Planning Application Ref: EG/6/18/RES

Location: Eastergate Fruit Farm, Barnham Road, Eastergate

Description of works: Approval of reserved matters following outline consent EG/71/14/OUT for the erection of 60 No. dwellings with new vehicular access, open space & ancillary works.

Planning Layout with removed
trees & hedgerows shown.

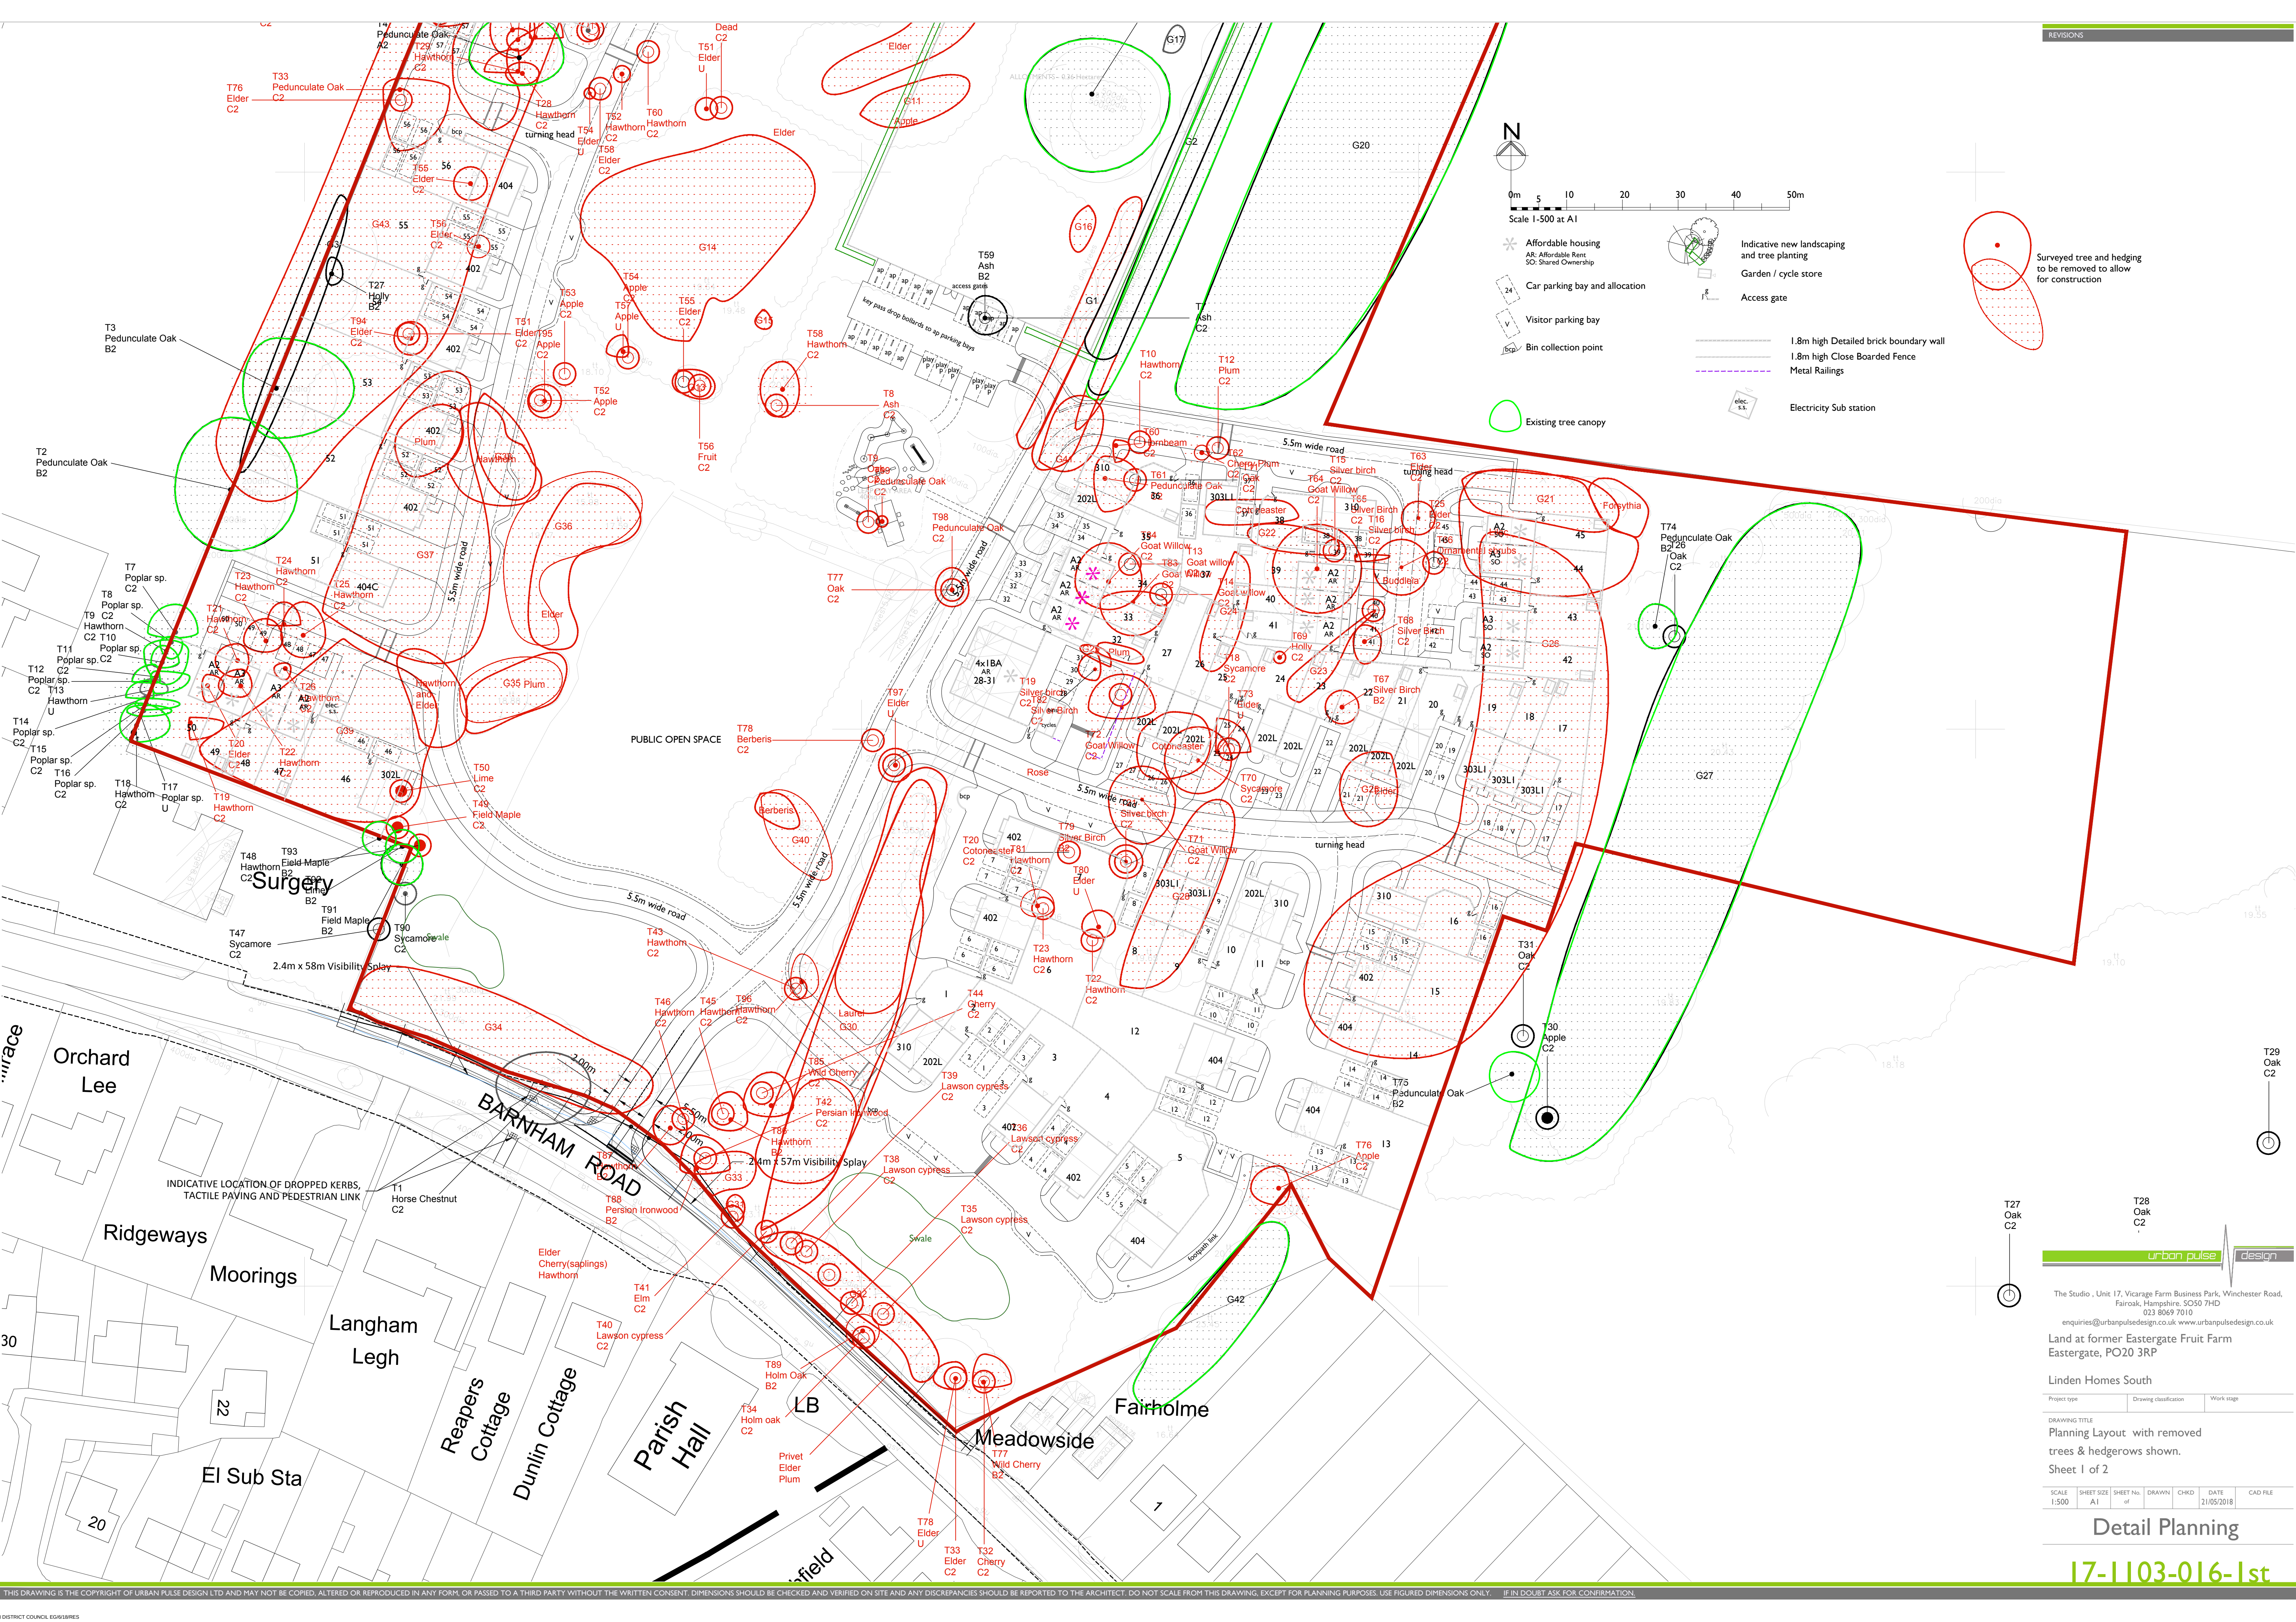
- I have referred to the subsequent and latest Site Plan Planning Layout Sheets (ref:17-1103-005 & 006) which appear to reflect individual tree RPA's and more importantly shows a revised layout that seeks to accommodate the aforementioned and other significant trees, all to be retained.

- We have to date received no accurate Tree Protection Plan overlaying the latest site plan layout.

- I am pleased to see there is now intent to retain T4, T5 and T74 within the development, but I cannot be satisfied that this will be achievable until we receive a Tree Protection Plan overlaying the final proposed site design layout, with supporting Arboricultural Method Statement where RPA incursion is anticipated.
- In the absence of the above information, were development to now proceed this could result in loss of trees important in the local landscape (some of which are subject to a Tree Preservation Order) or being located so close to that building development as would be likely to result in significant physical damage to the tree[s], thereby diminishing the health, appearance and longevity of the same in conflict with policy GEN7 of the Arun District Local Plan.
